Subject: Planning ref: 20/01127/F. Hatch End Old Poultry Farm Steeple Aston Road Middle Aston Bicester OX25 5QL.

Crime Prevention Design Advisor | Oxfordshire | Local Policing | Thames Valley Police

1 Proposed Site Plan
Scale: 1:500

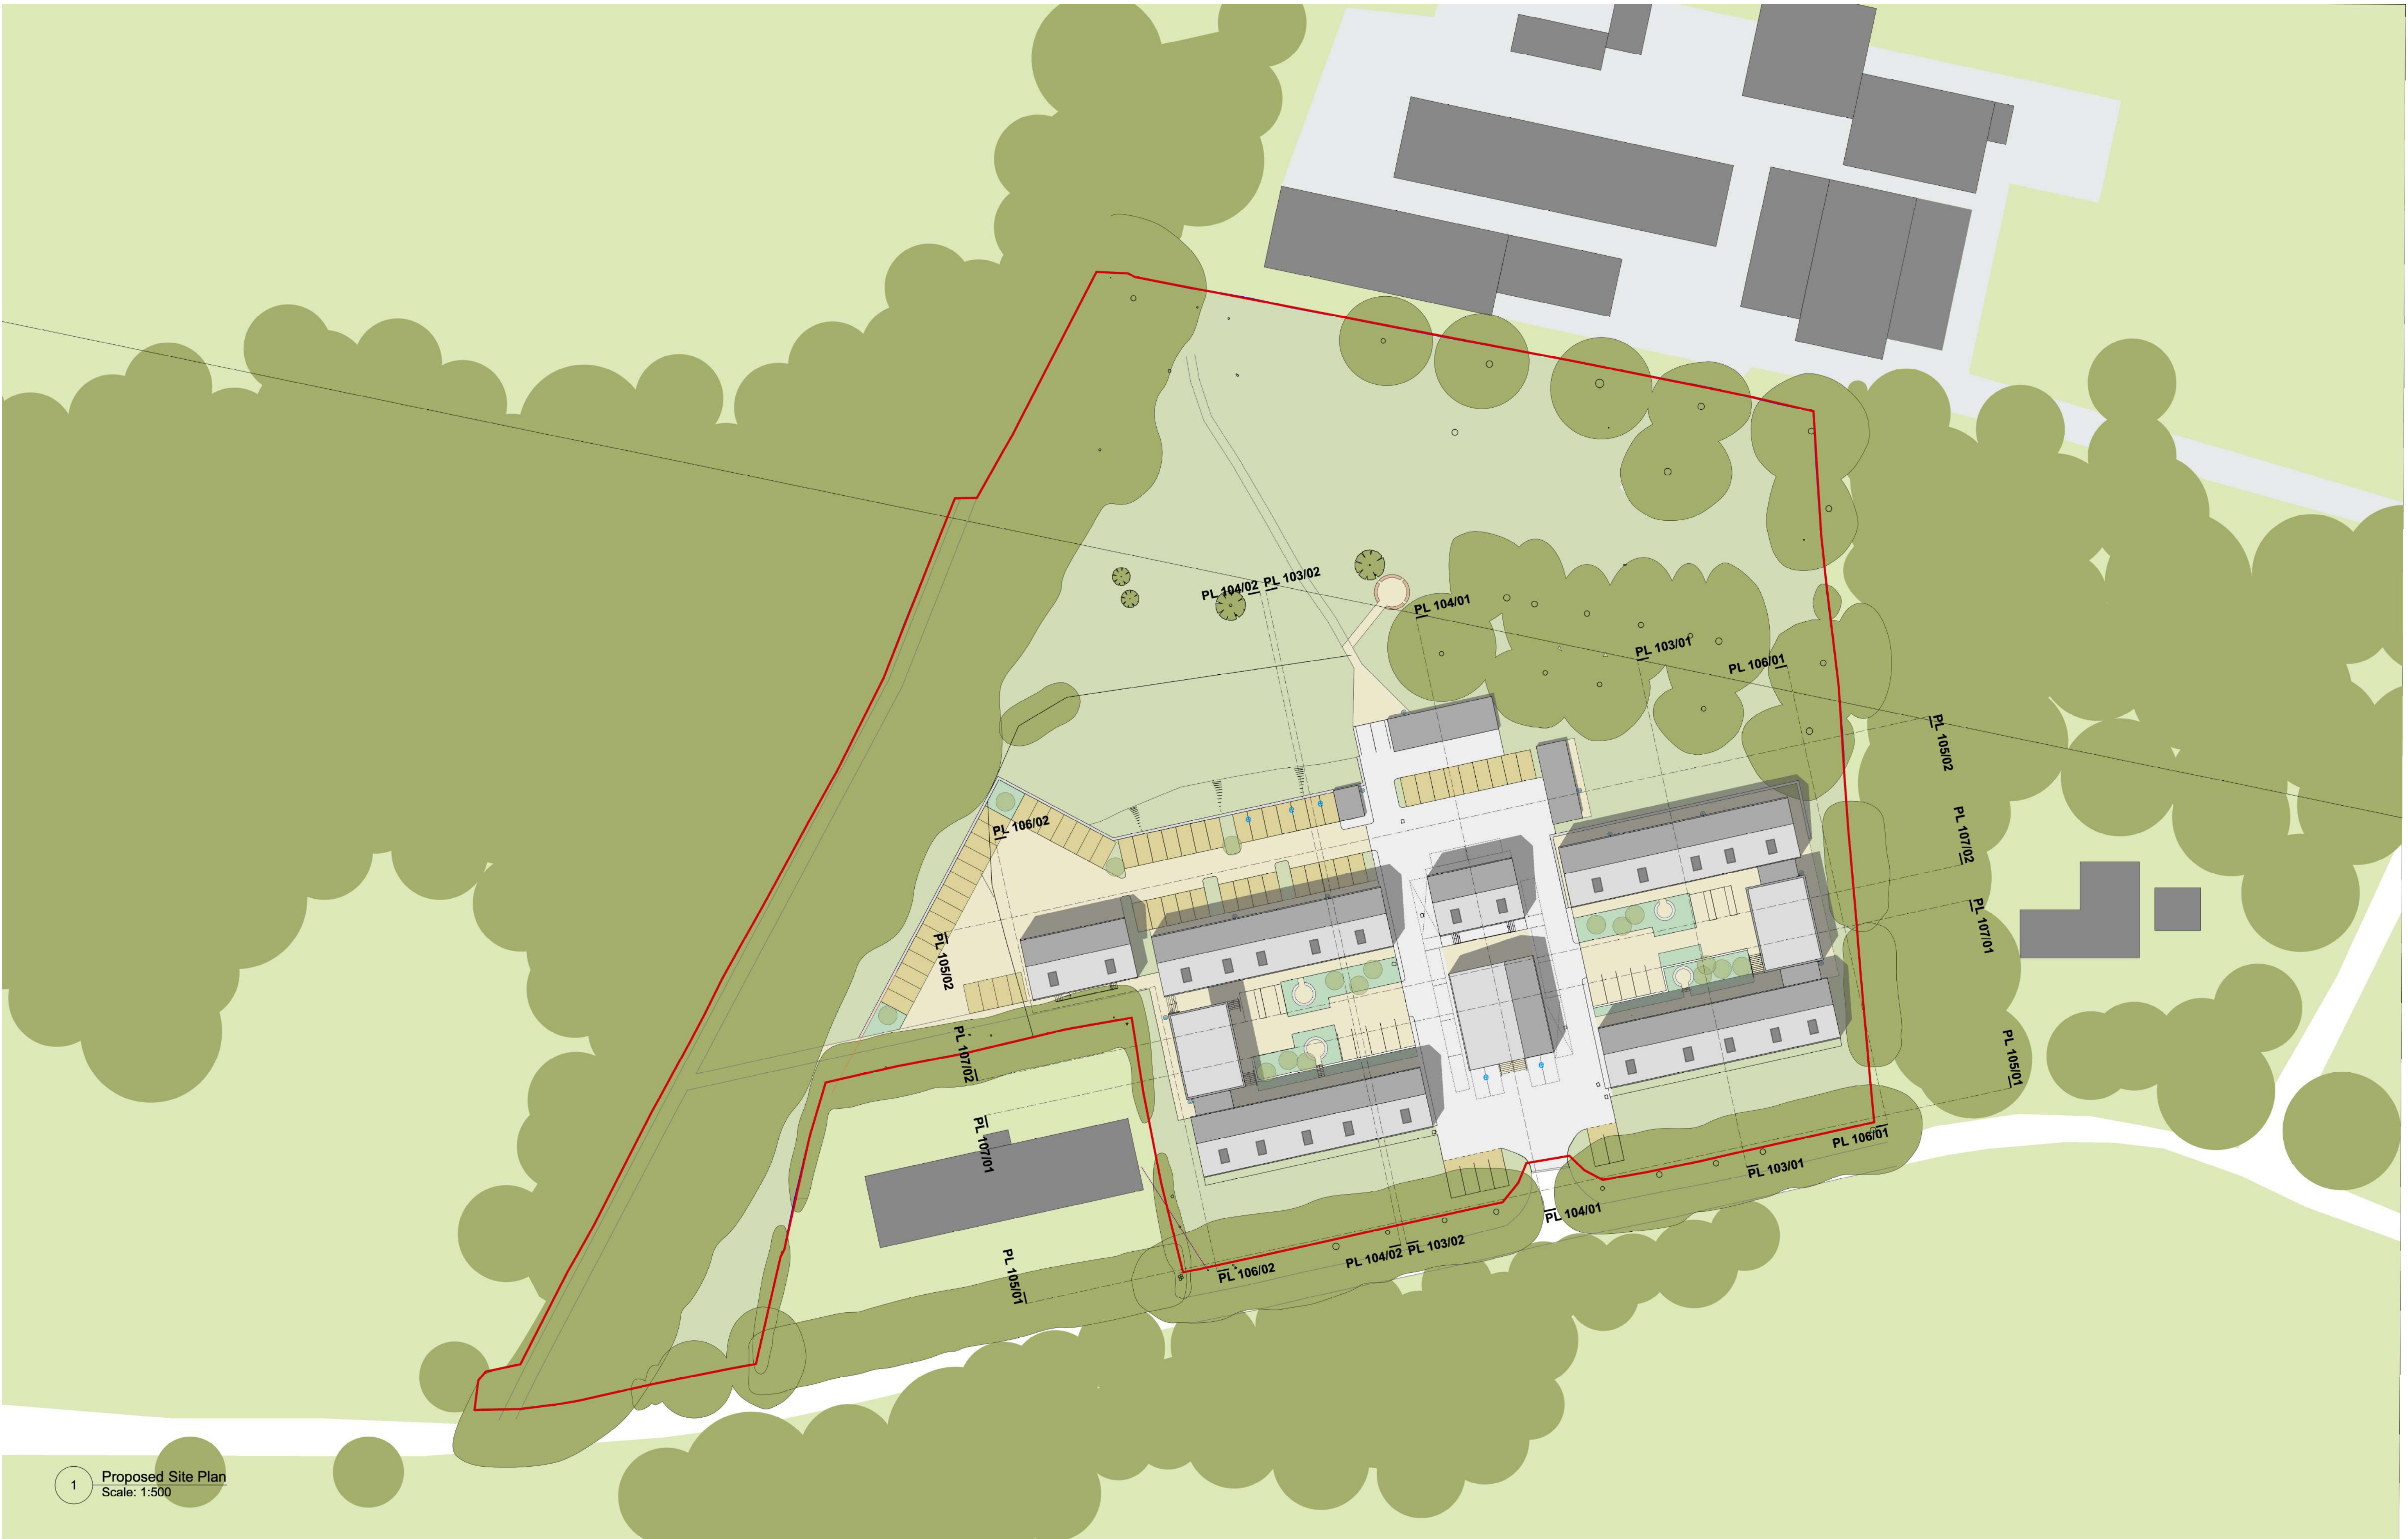
- I am concerned that the plans appear to show no physical security feature at the main site entrance. I recommend that gates or similar are provided to ensure the site can be secured against vehicular intrusion outside the hours of operation of the site.
